From: elliottr [elliottr@kvfr.org]
Sent: Tuesday, October 04, 2011 1:16 PM
To: Brenda Larsen; Dan Valoff
Cc: seemillerj; John Sinclair
Subject: Thrall Road Short Plat

KVFR input regarding Thrall Road Short Plat (SP-11-00006)

THRALL ROAD SHORT PLAT
PART OF SECTION 27, T. 17 N., R. 19 E., W.M.
KITITAS COUNTY, WASHINGTON

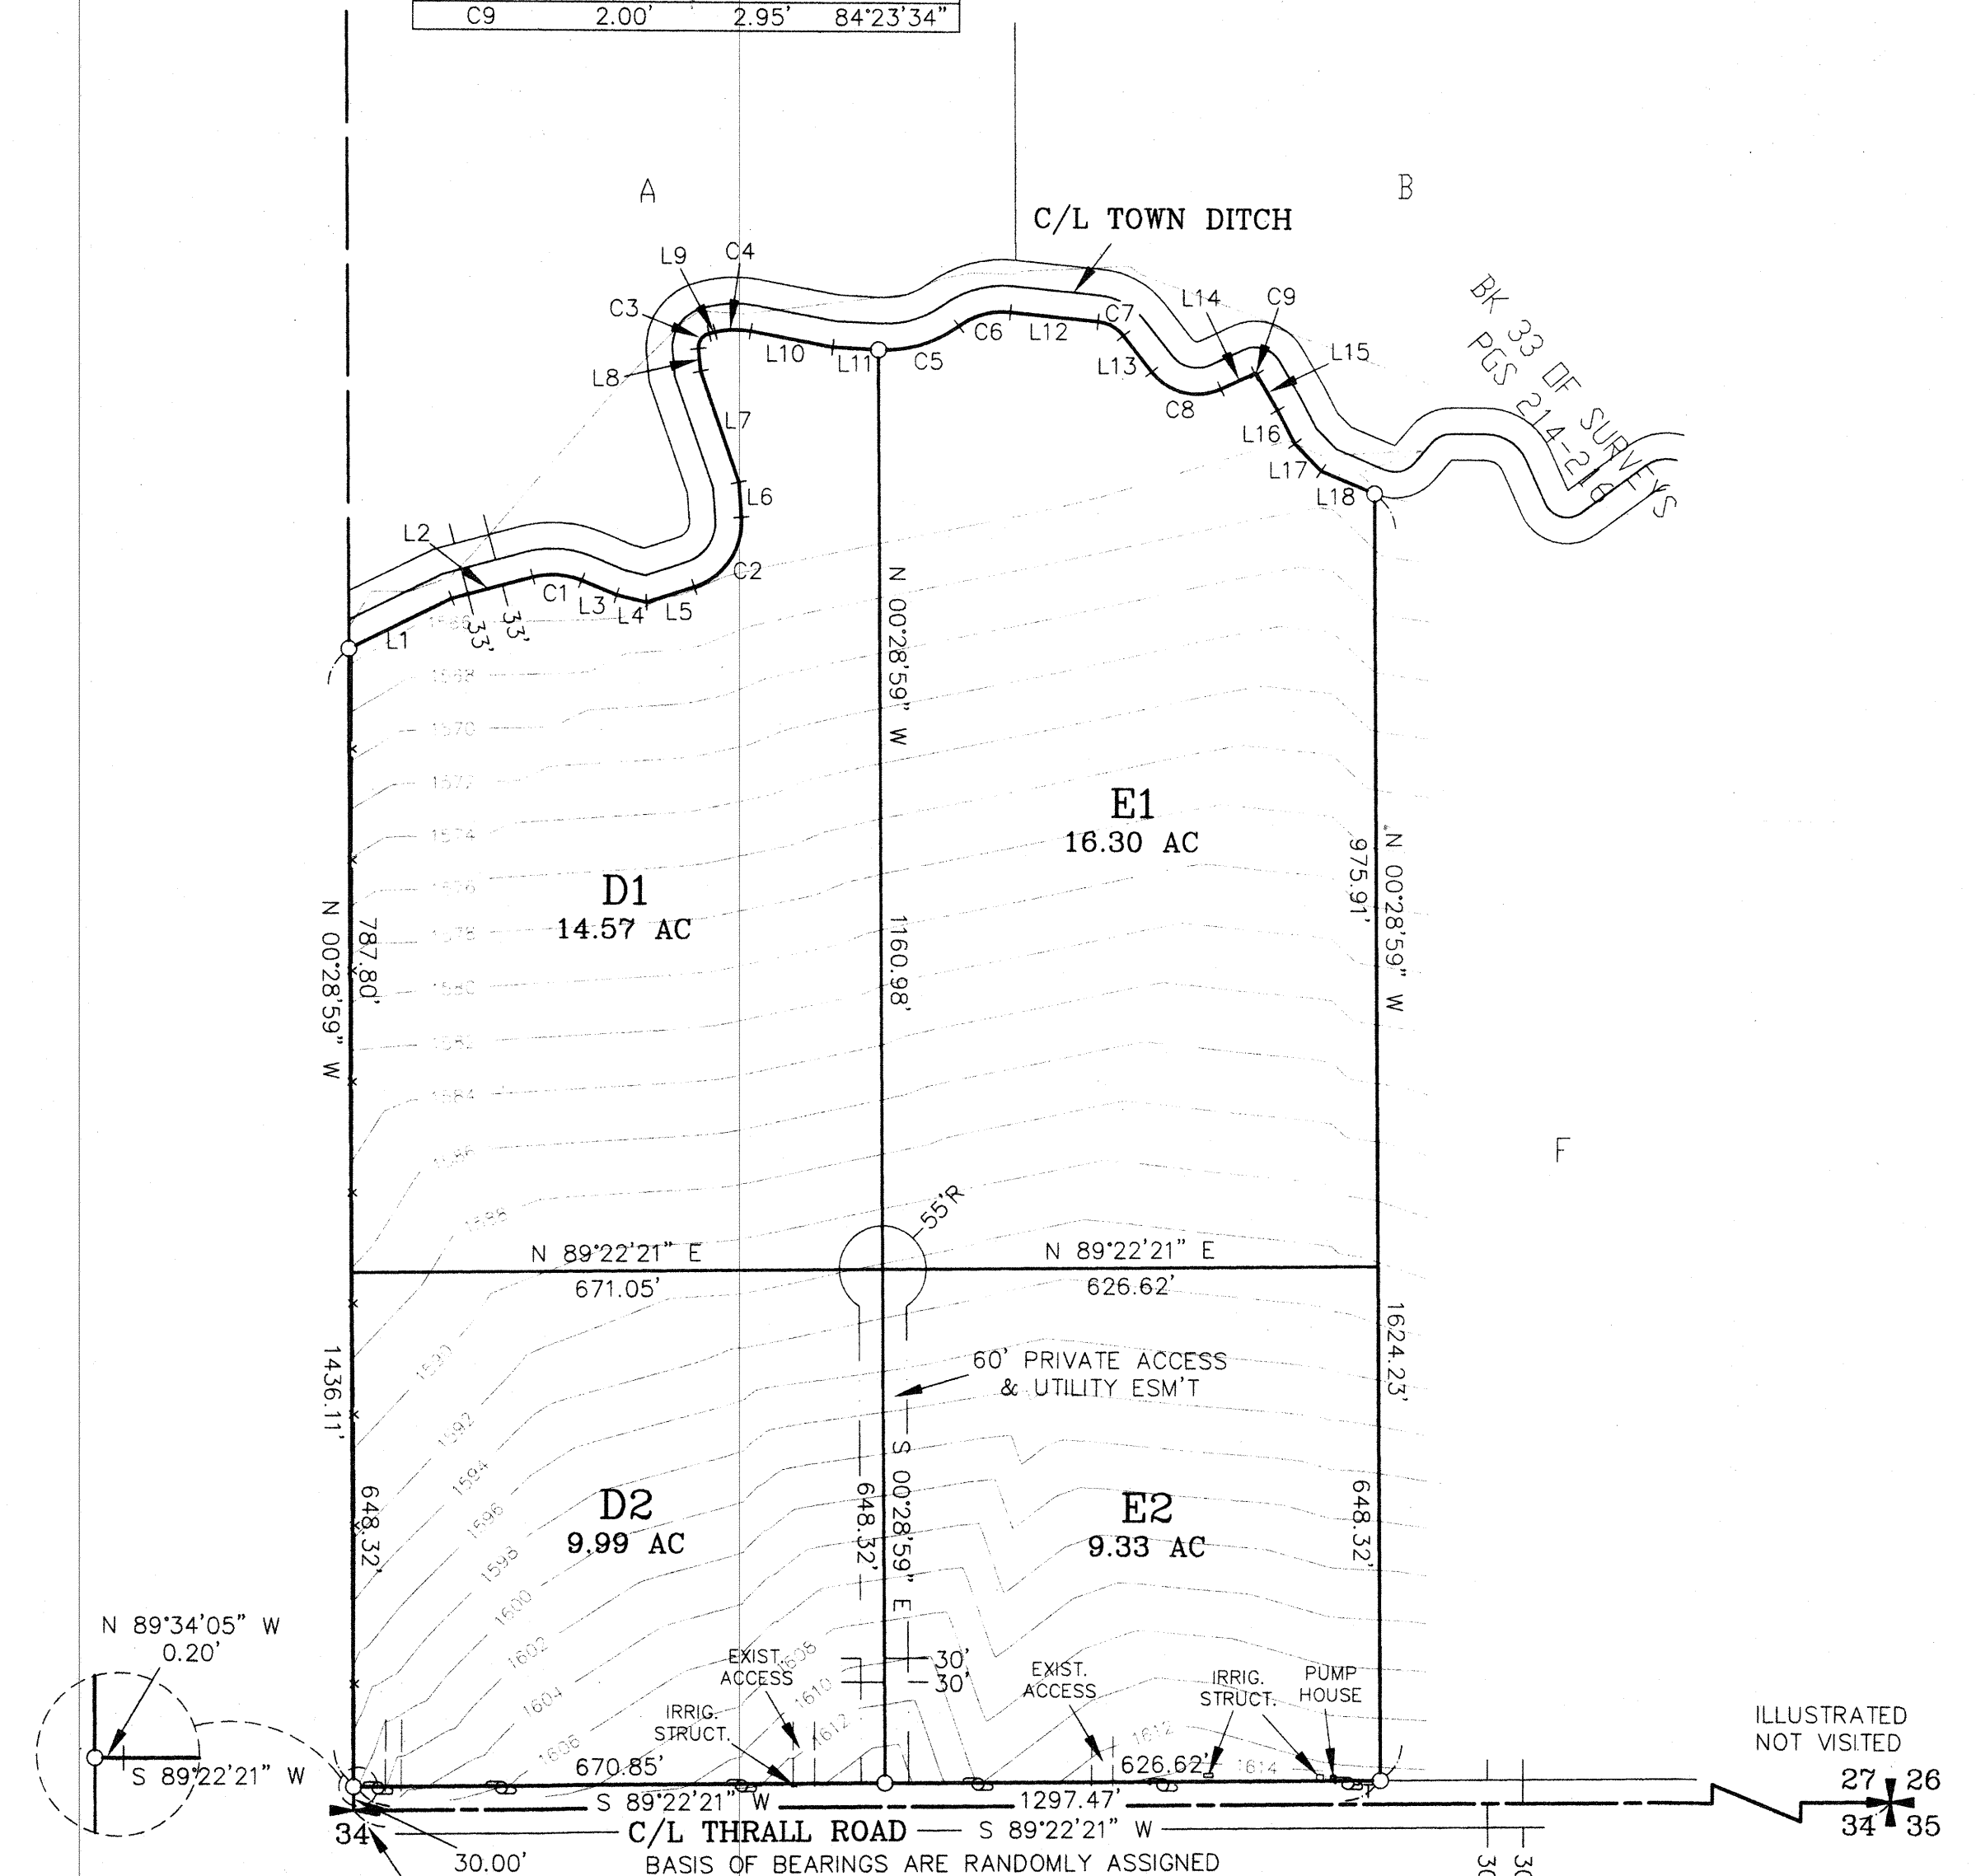
1. When the property develops, we request that the individual parcels be addressed in a manner that provides for clear identification from both directions of travel.
2. Access to the parcels be compliant with Appendix D of the applicable IFC.
3. Water supply be addressed per Kittitas County Code at the time of development.
